**REQUEST**

Current Zoning: N1-A (Neighborhood 1-A)  
Proposed Zoning: CR(CD) (Regional Commercial, Conditional)

Approximately 4.85 acres located west of Steele Creek Road and north of the Interstate 485 ramp.

The petition proposes to develop a vacant property in the Steele Creek community with up to 122,500 square feet of self-storage uses.

REZONING
SITE PLAN
SHEET **C100**

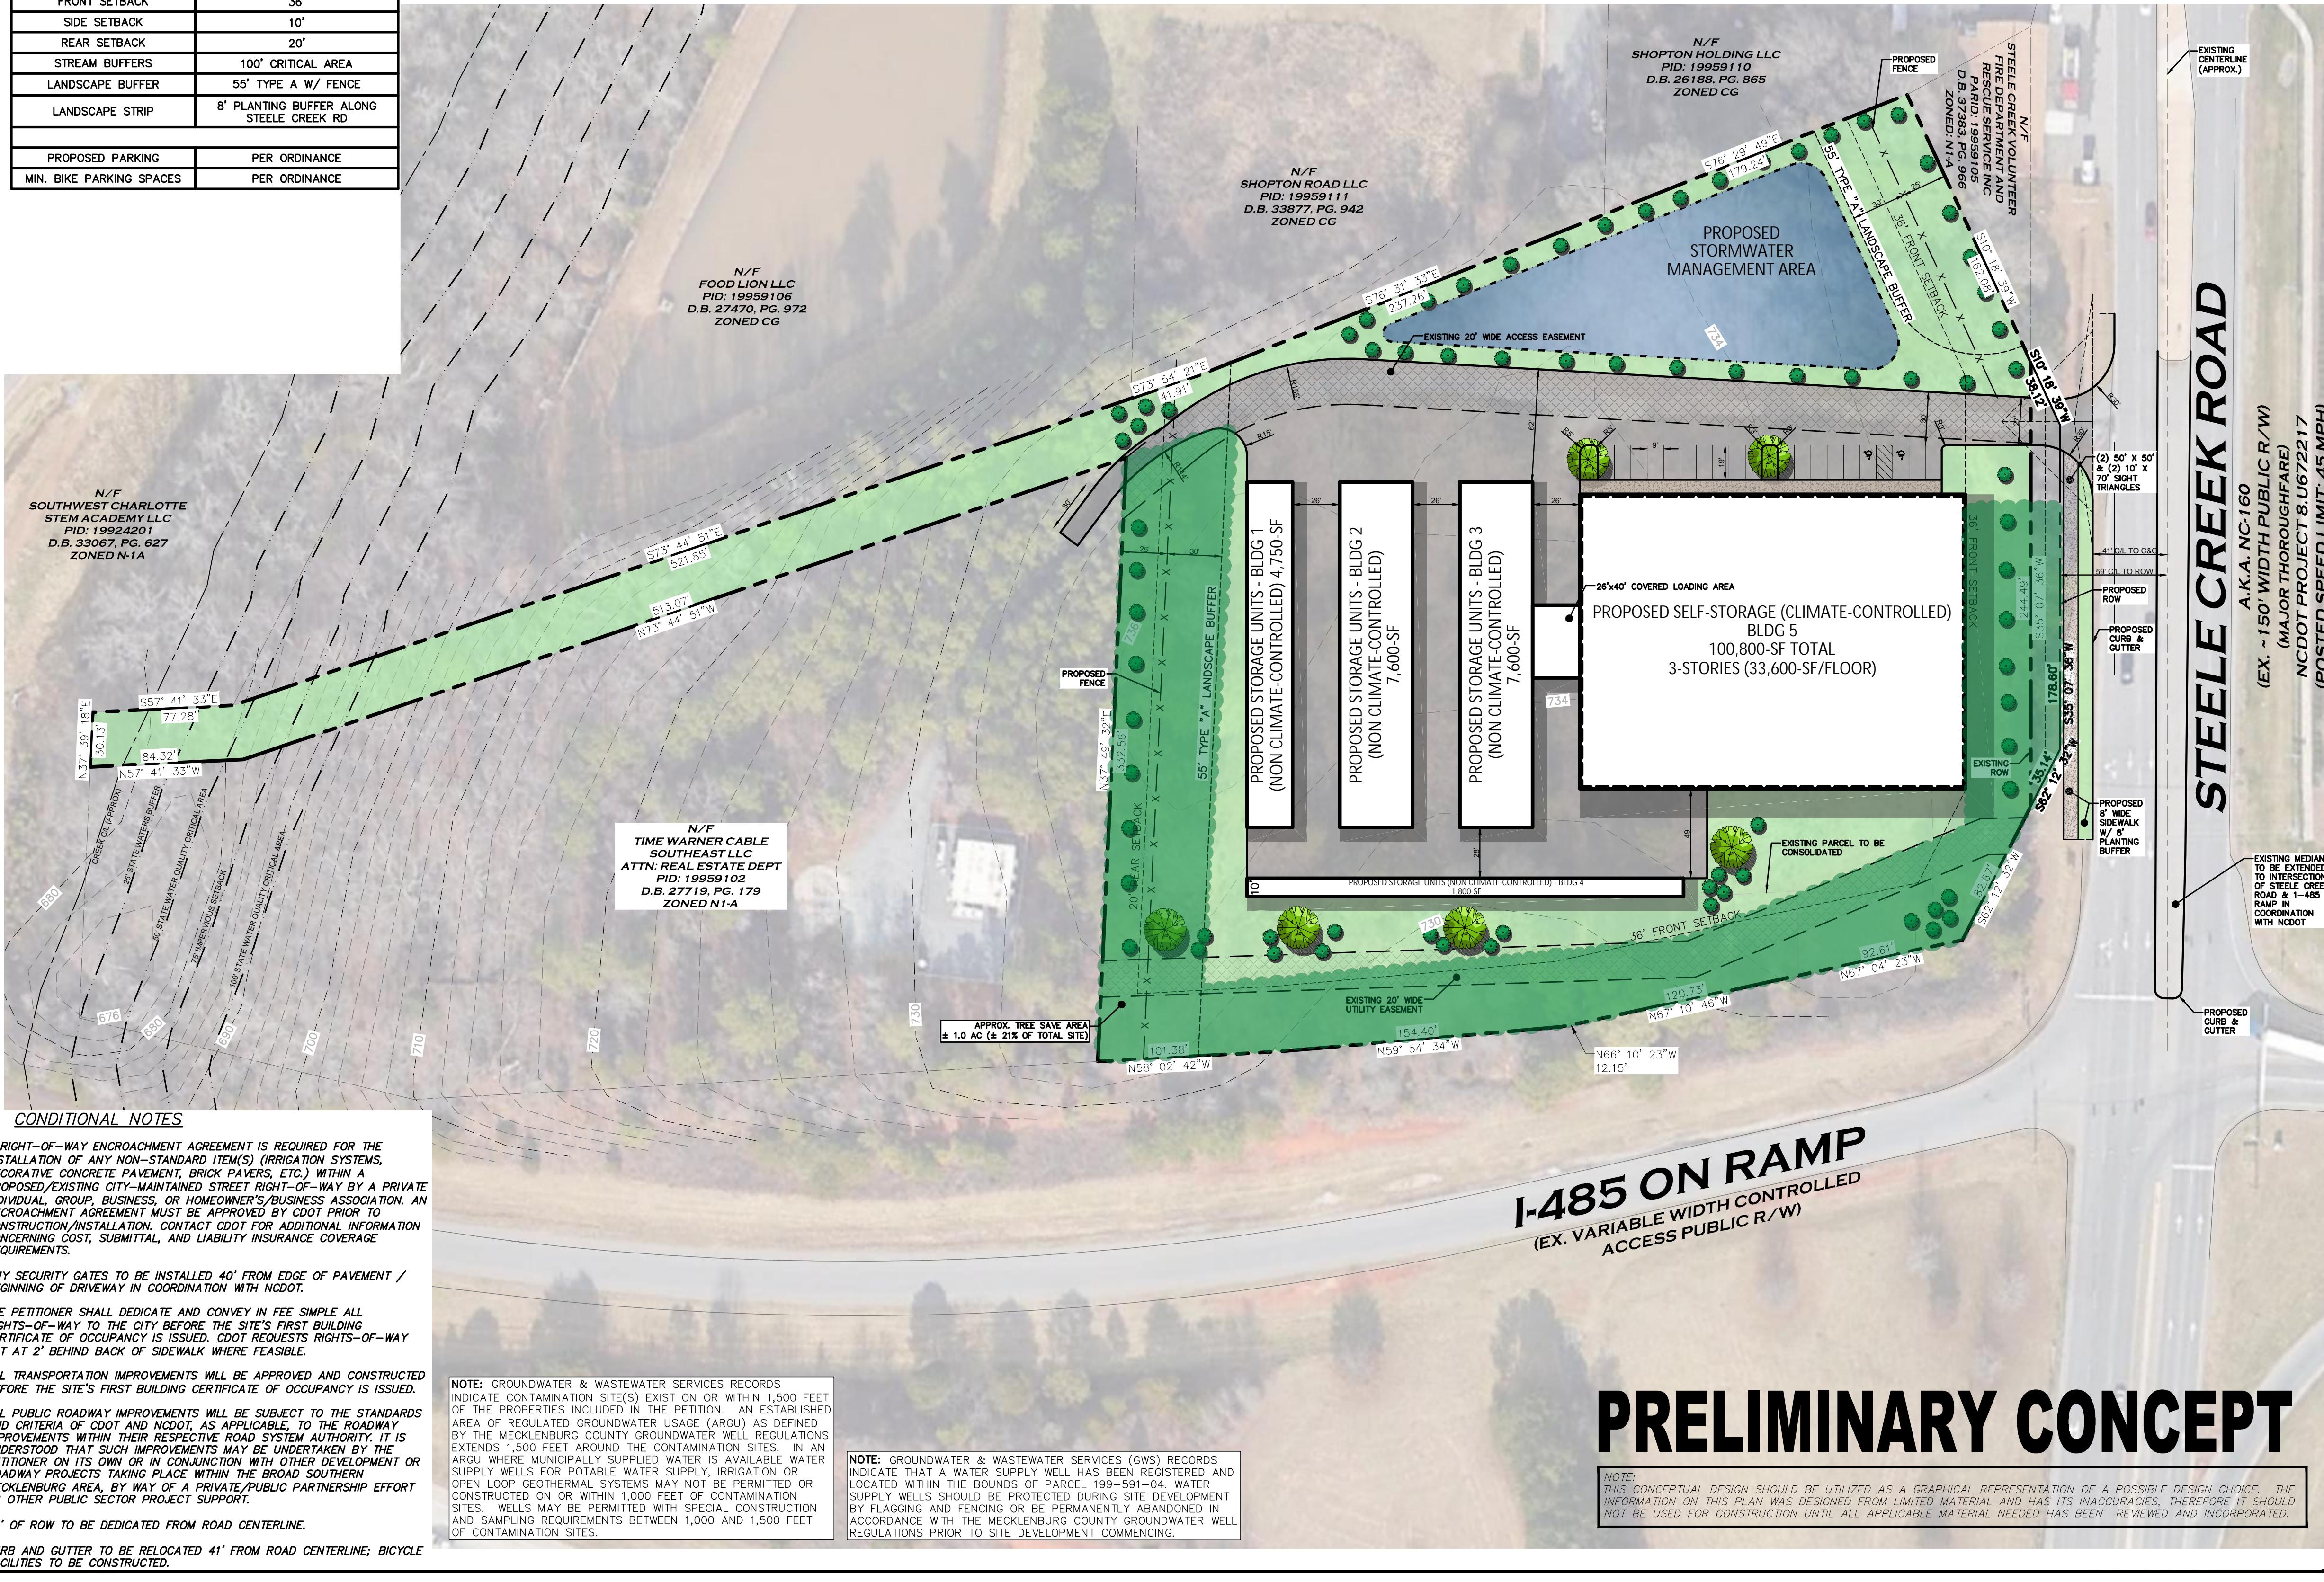
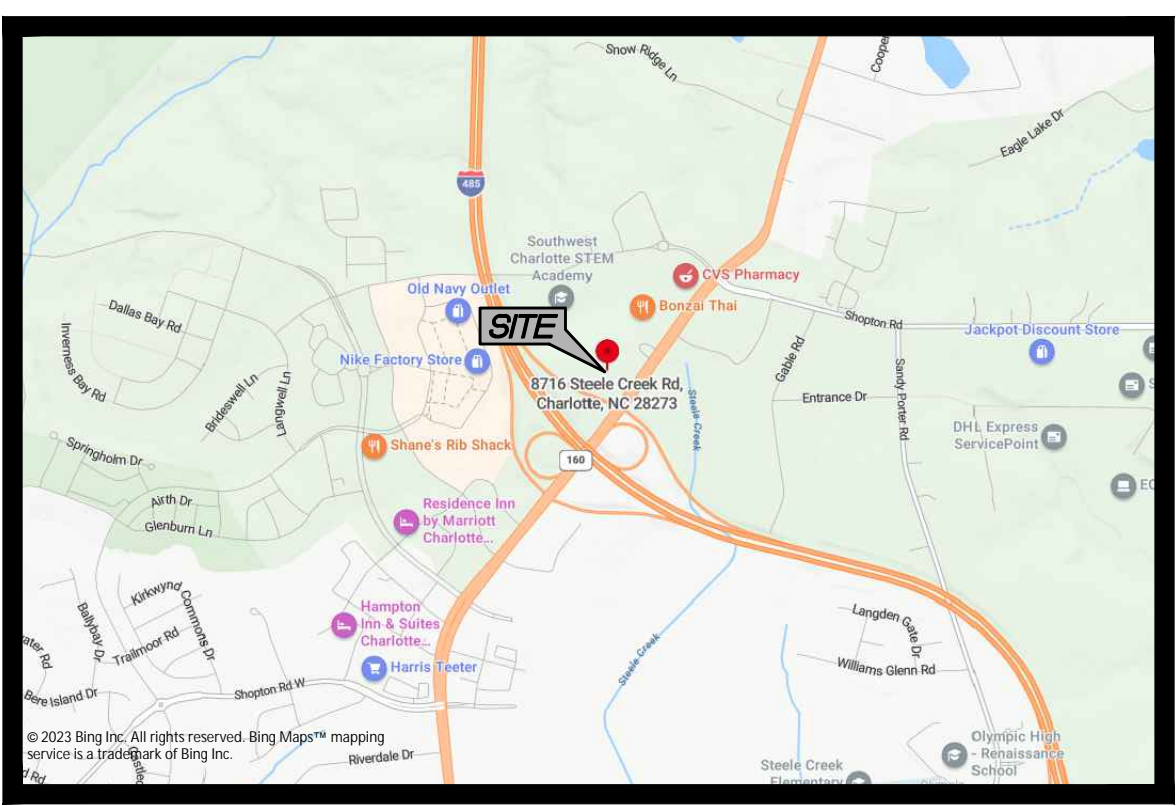
1. Adjust the square footages so that the maximum gross floor area equals the sum of the climate controlled self-storage and outdoor self-storage. **ADDRESSED**
2. Show tree save area on site plan. This site is required to provide a minimum of 15% tree save. **ADDRESSED**
